DECISION DELEGATED TO HEAD OF PLANNING

Application No: H17-0260-26 **Applicant:** Mr R Bright
Proposal: Proposed orangery to rear of dwelling including internal wall removal
Location: Ivy House Gosberton Bank Gosberton
Terminal Date: 15th May 2026

Rear Elevation

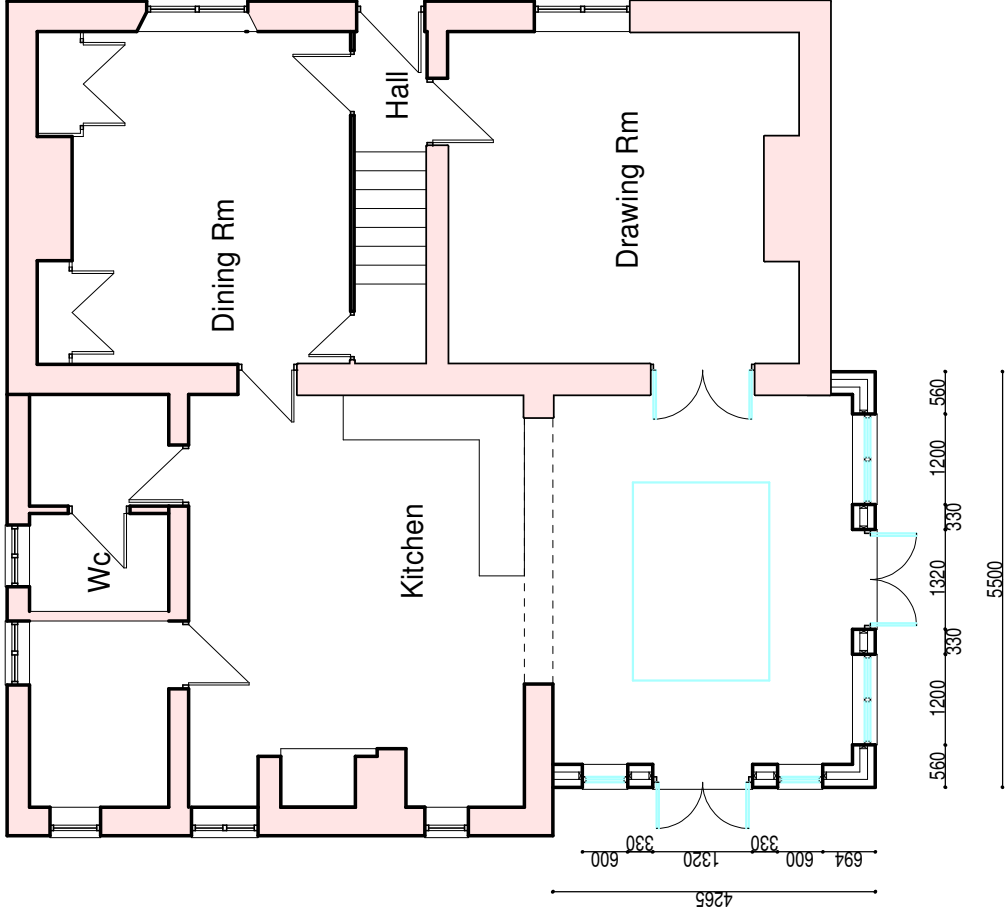
The proposed extension is a cumbersome, ungainly feature, which bears no relation to the existing dwelling either stylistically or in terms of scale.

The proposal would extend beyond the indent which it is to be located within. This would reduce the integration of the extension, as the slight protrusion would appear unusual. As such, the proposal would fail to respect the existing proportions or massing of the dwellinghouse, and would negatively affect the legibility of the original form.

The use of block and render would further weaken the integration. Whilst render is present on the site currently, it is extremely limited. The distinctly modern design, clashes with the prevailing appearance of the listed building. Moreover, the proposal would feature elements which do not fully relate to the host property such as brick soldier course lintels above the proposed windows.

As a part of the proposal, elements of existing brickwork would be removed. From the submitted HIA, this would primarily be material added relatively recently. That being said, it is not clear that this material is exclusively modern, and therefore there may be some loss of the original fabric of the building. Regardless, the proposal would impact upon the readability of the original features and proportions of the dwelling.
